Application No: LU/252/21/PL
Site Address: 6 Selborne Place Selborne Road Littlehampton BN17 5NH
Description of works: Change from current 8 bedroom large house in multiple occupation (sui generis) to a 9 bedroom large house in multiple occupation (sui generis). This application affects the character & appearance of the Littlehampton Sea Front Conservation Area.

Thank you for your internet representation made on 17th September 2021 which has been recorded as an objection with the comments as follows:

OWPC40482

Proposed Ground Floor Plan 1:50

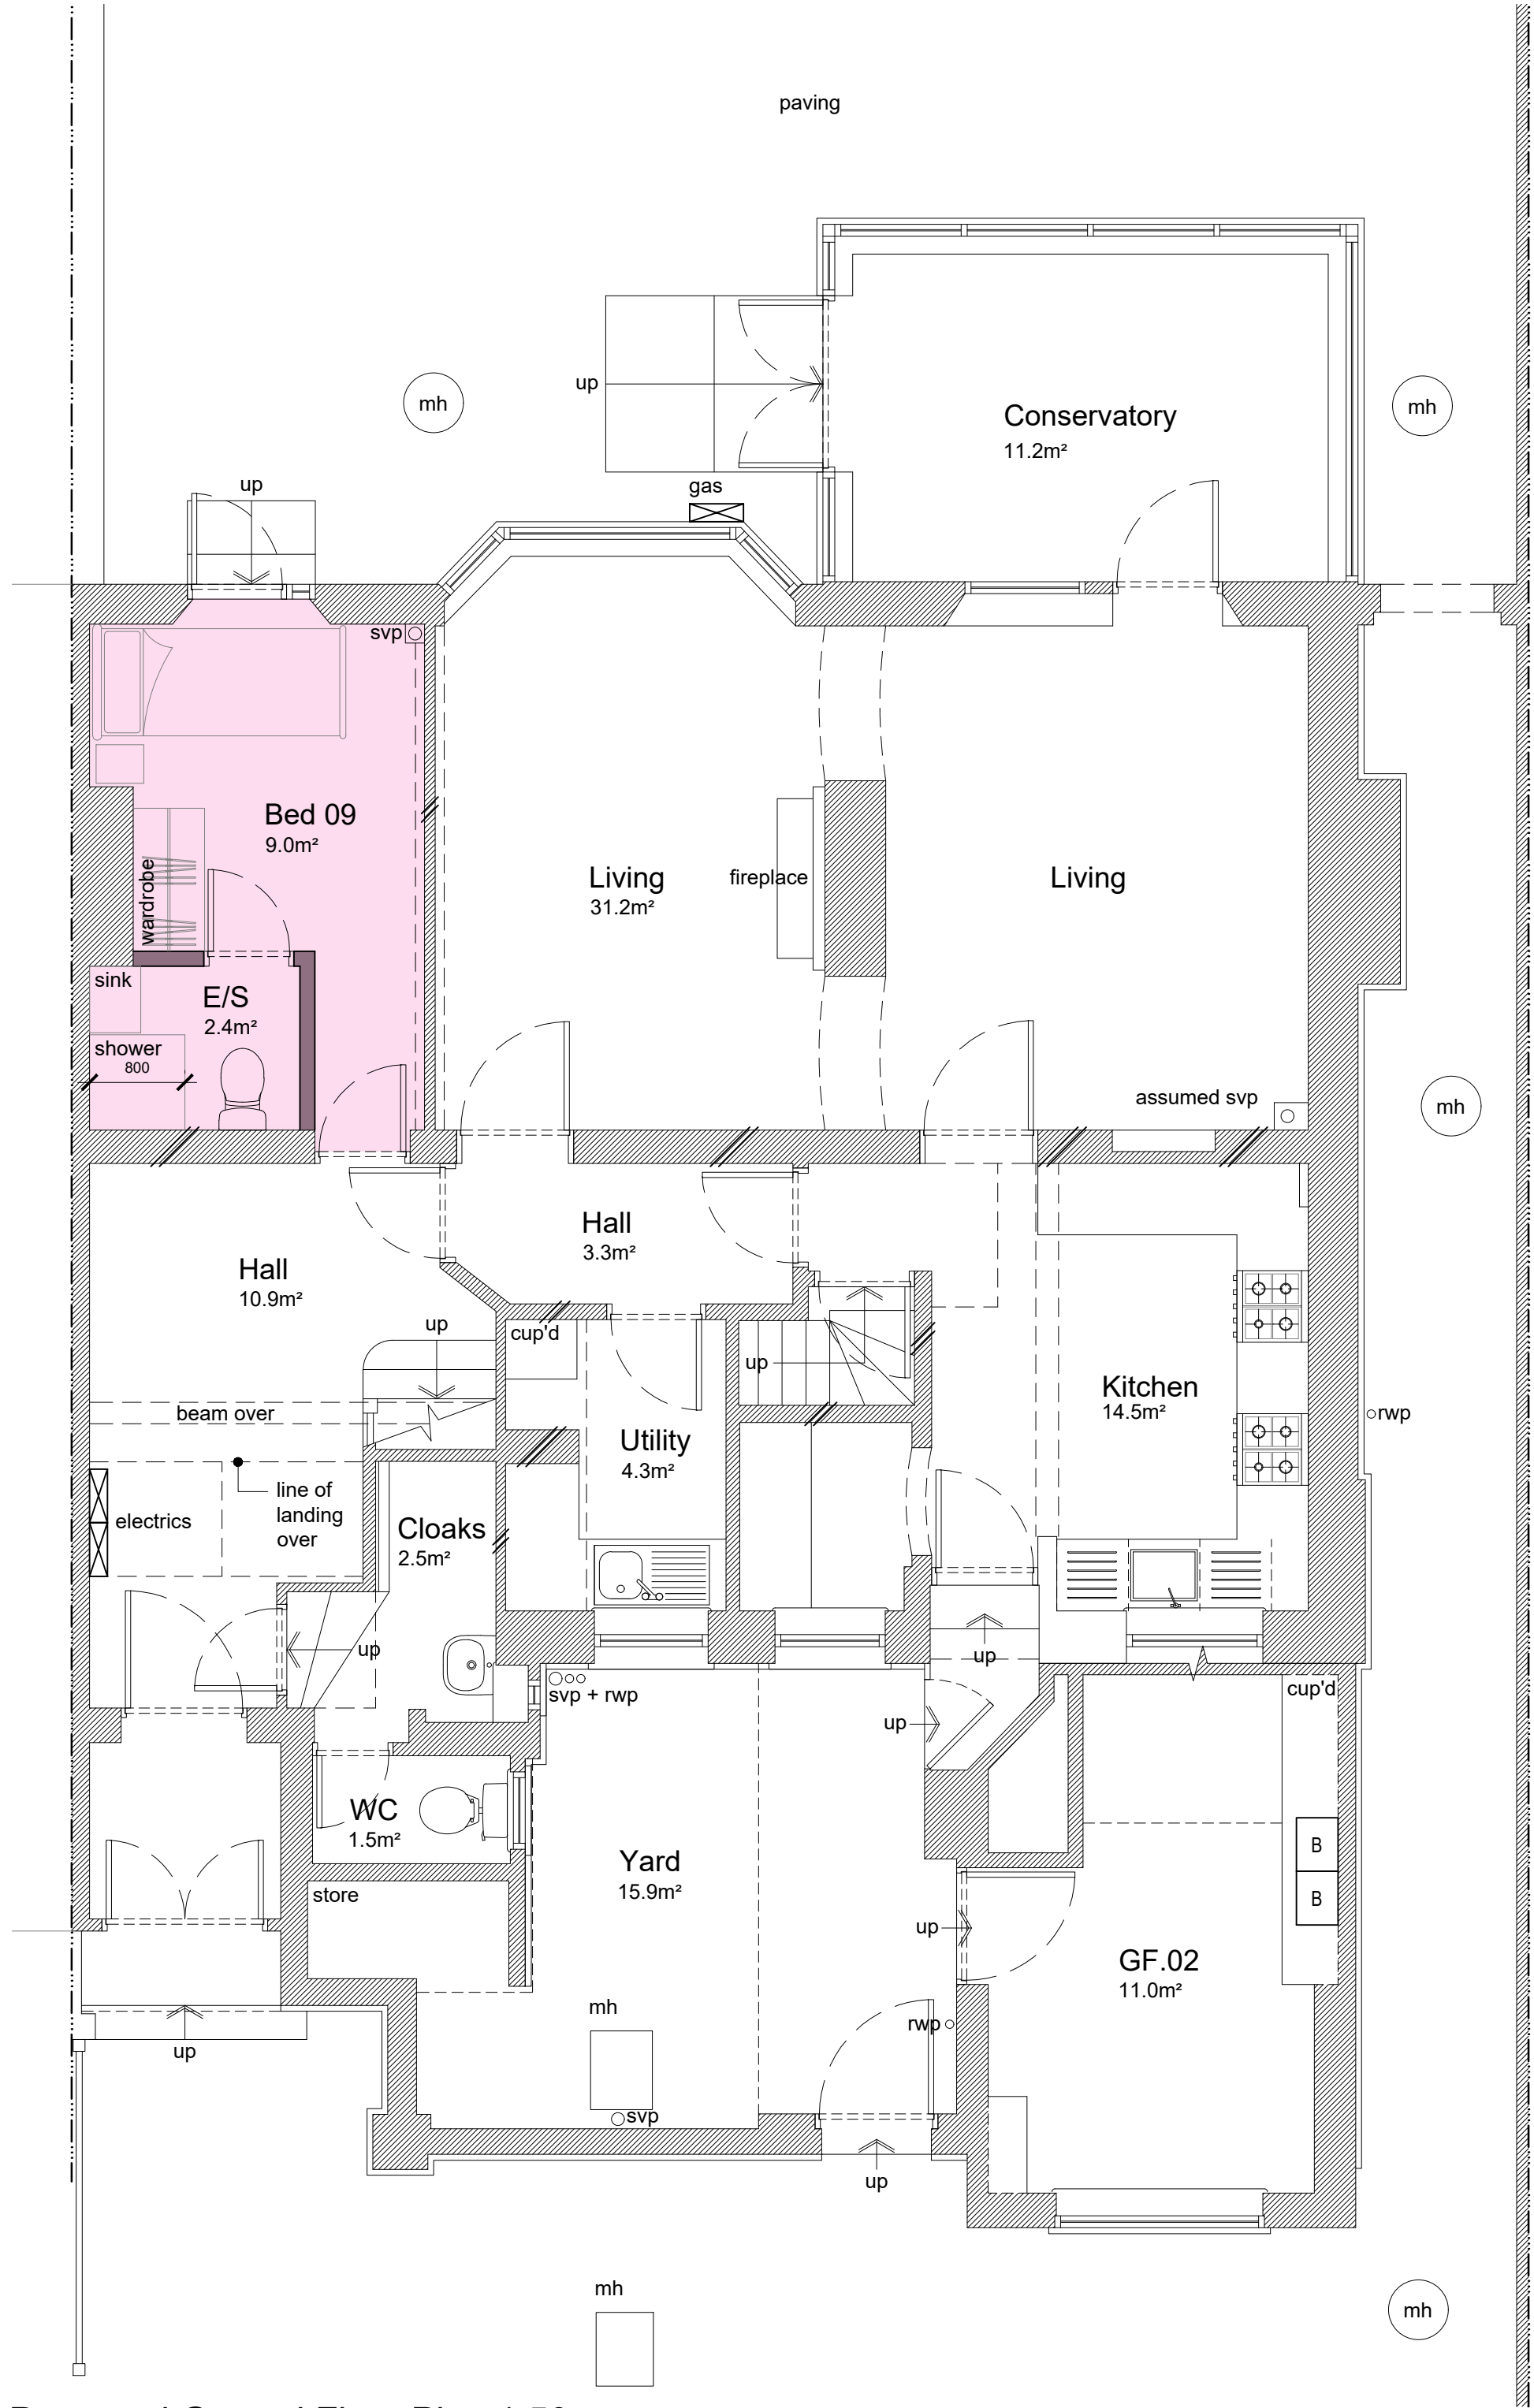
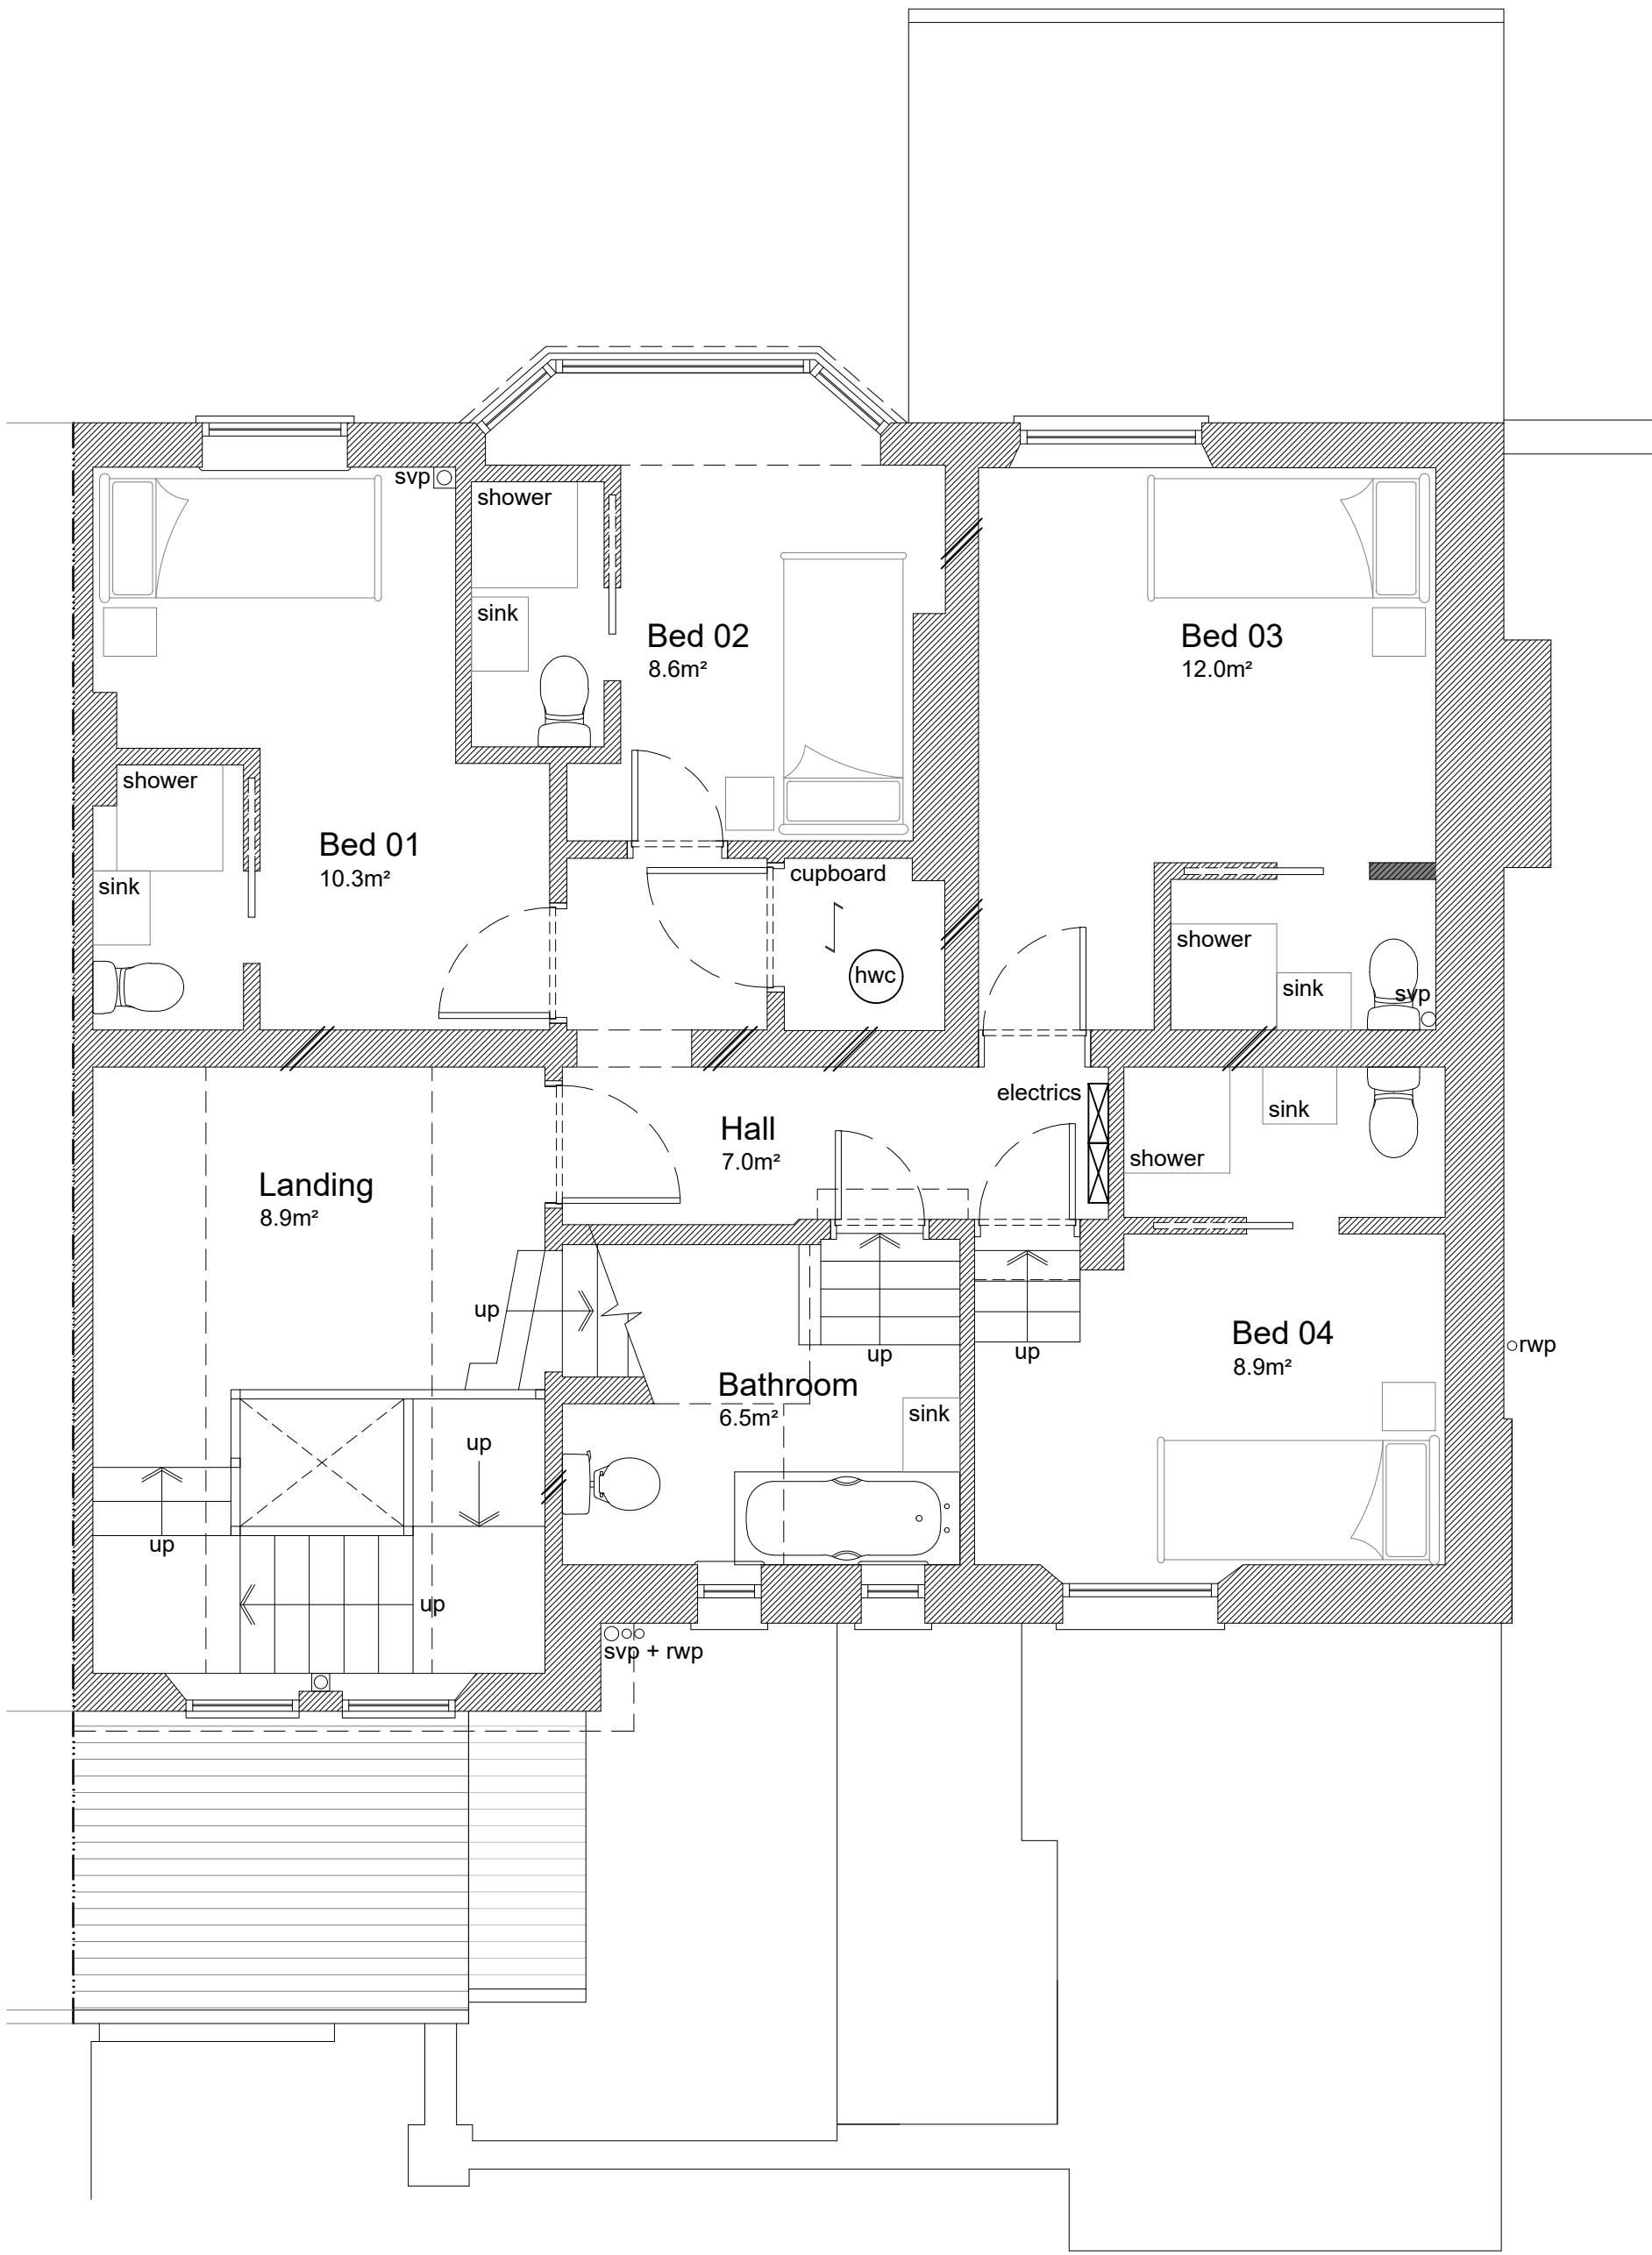
These proposals were considered by the Town Council's Planning and Transportation Committee at the meeting on Monday 13th September 2021. The Town Council objects to this application on the grounds that the proposal fails to conform to the District Council's HMO Space Standards in respect of the size of the kitchen. The Standards specify that a kitchen in a property with a potential capacity of 13 residents should be 19.5m². The kitchen is 14.5m² and therefore deficient.
